# PLN-PUDSP21005-R5-PUDSP.pdf Markup Summary

**Subject:** Architect  
**Page Label:** [1] WB PUDSP 10.7.22-Cover  
**Author:** Ryan Howser  
**Date:** 11/8/2022 12:39:02 PM  
**Status:**  
**Color:** ■  
**Layer:**  
**Space:**

SHEET TITLE: SOUTHWEST AREA DEVELOPMENT PLAN

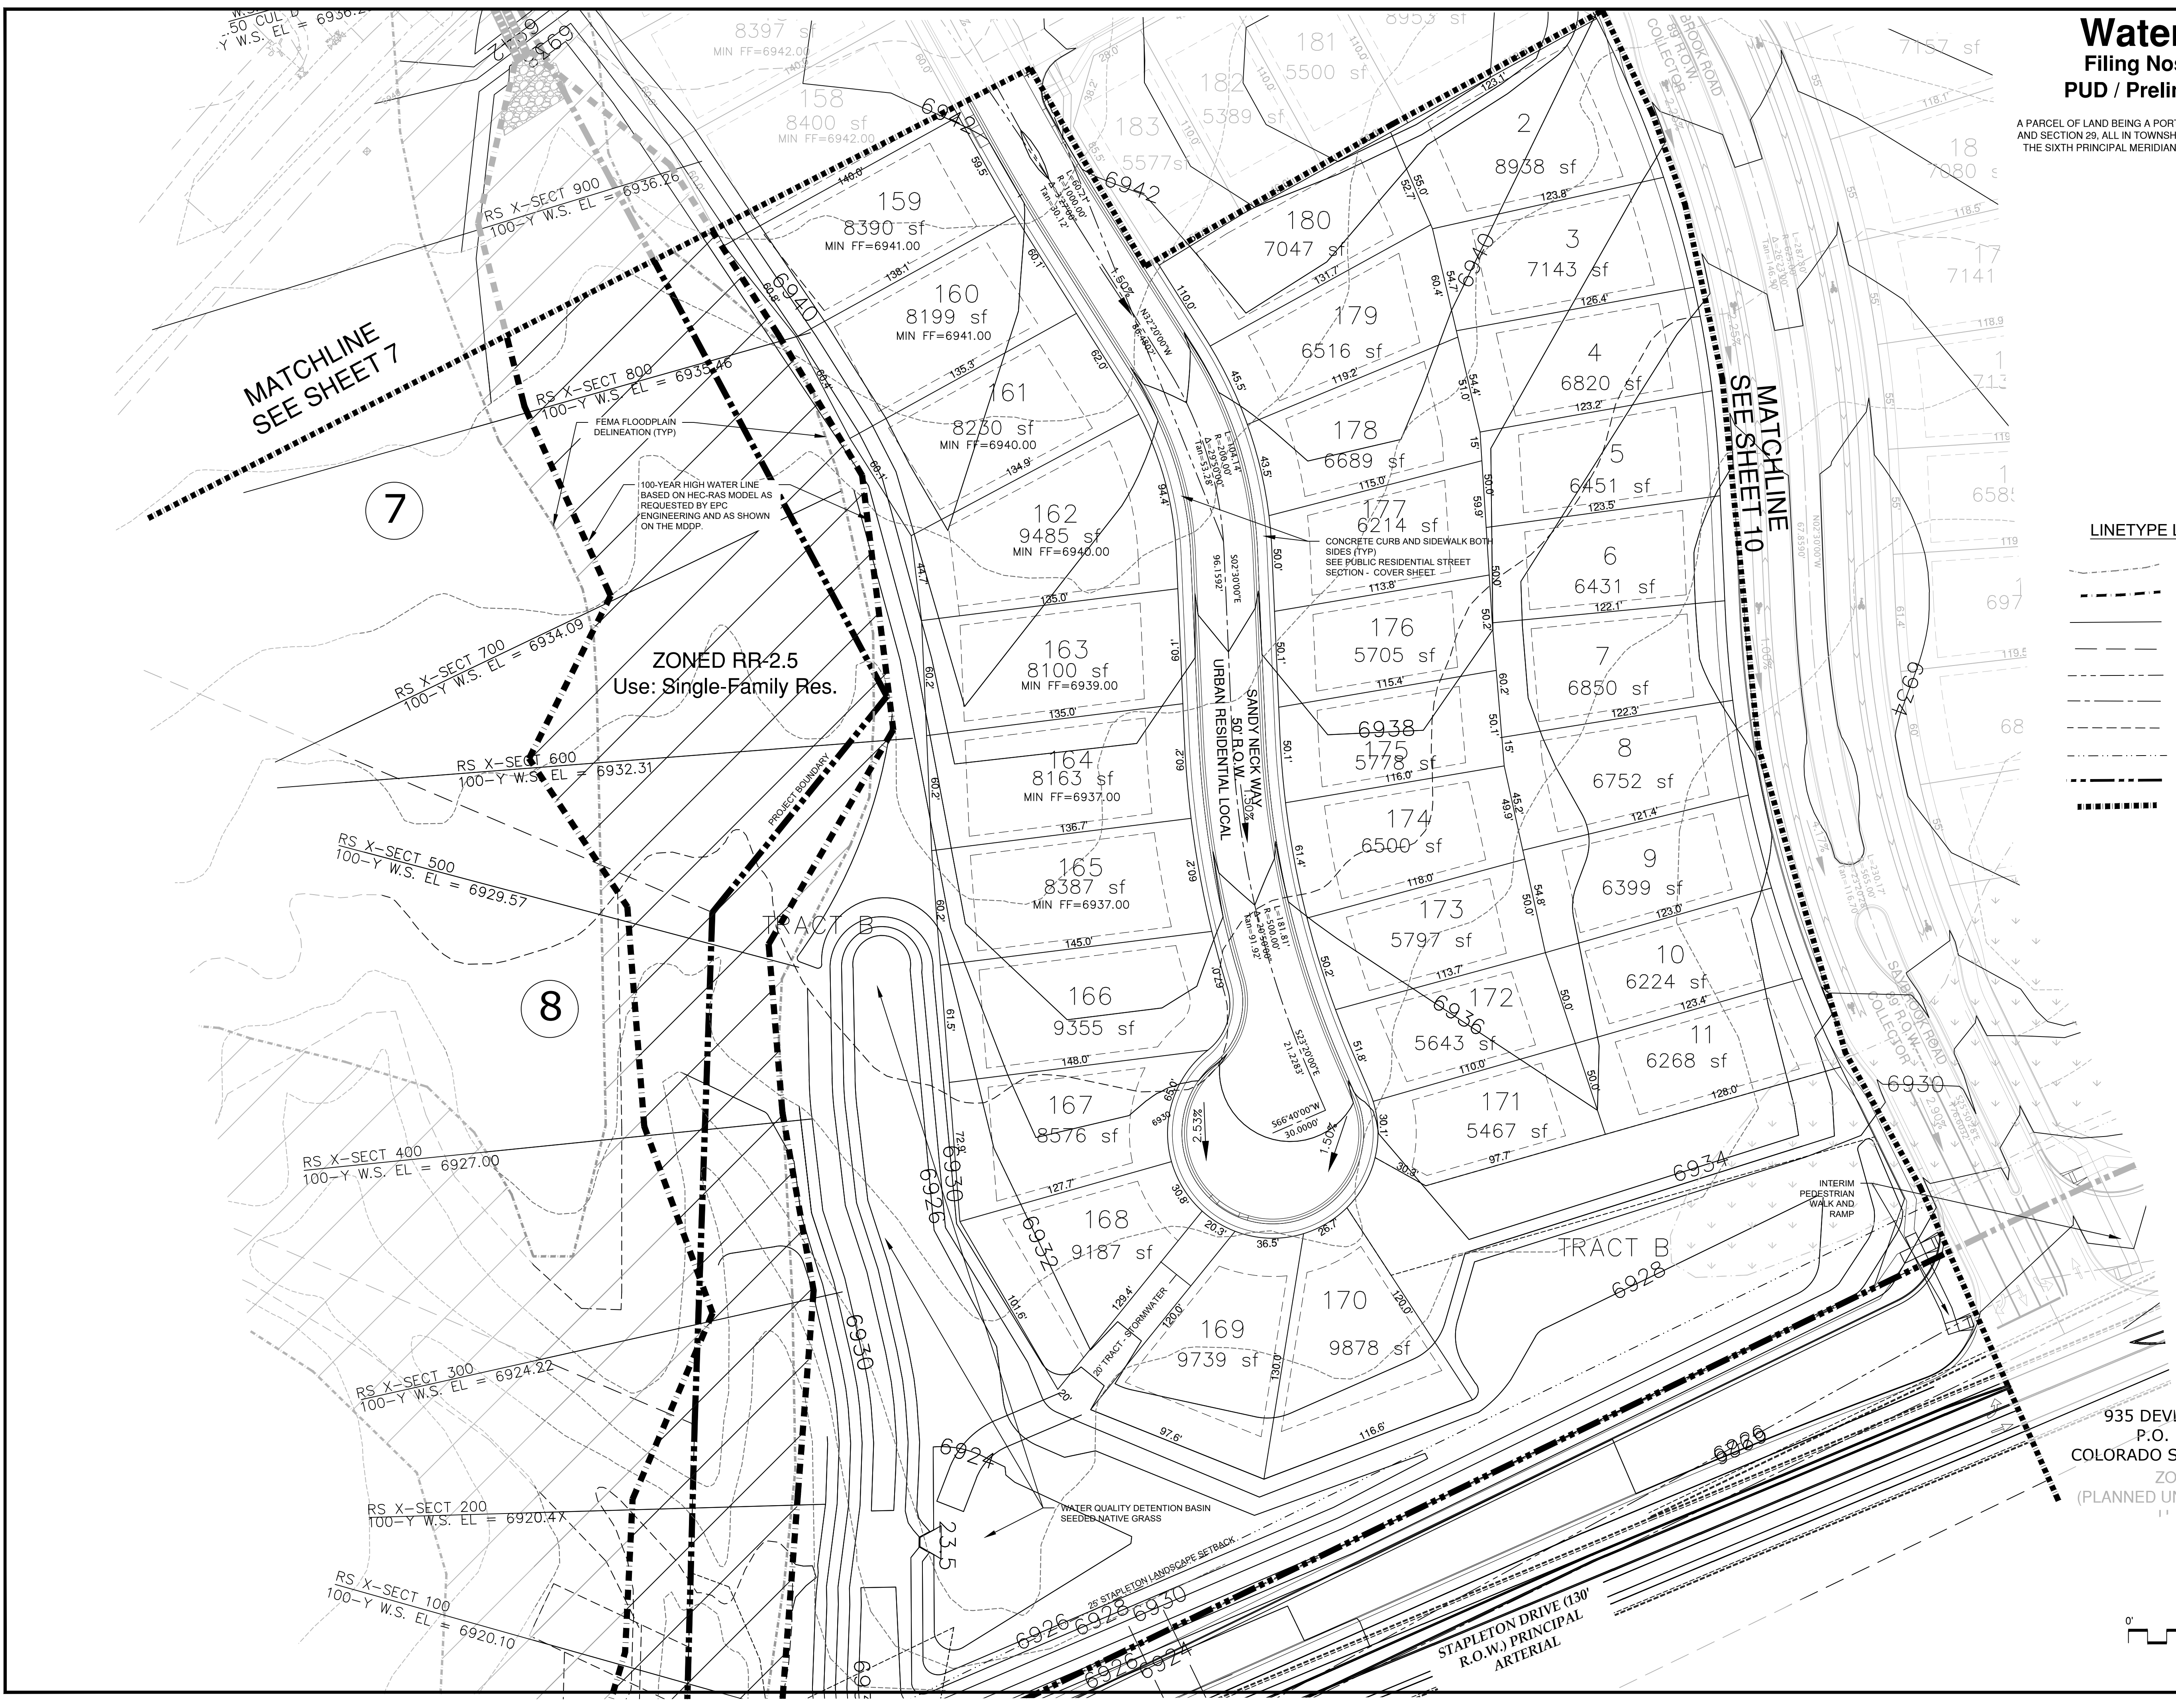
Label existing lot numbers  
**corrected**

Address why this floodplain is wider than FEMA floodplain

**label added to clarify 100 yr. high water line**
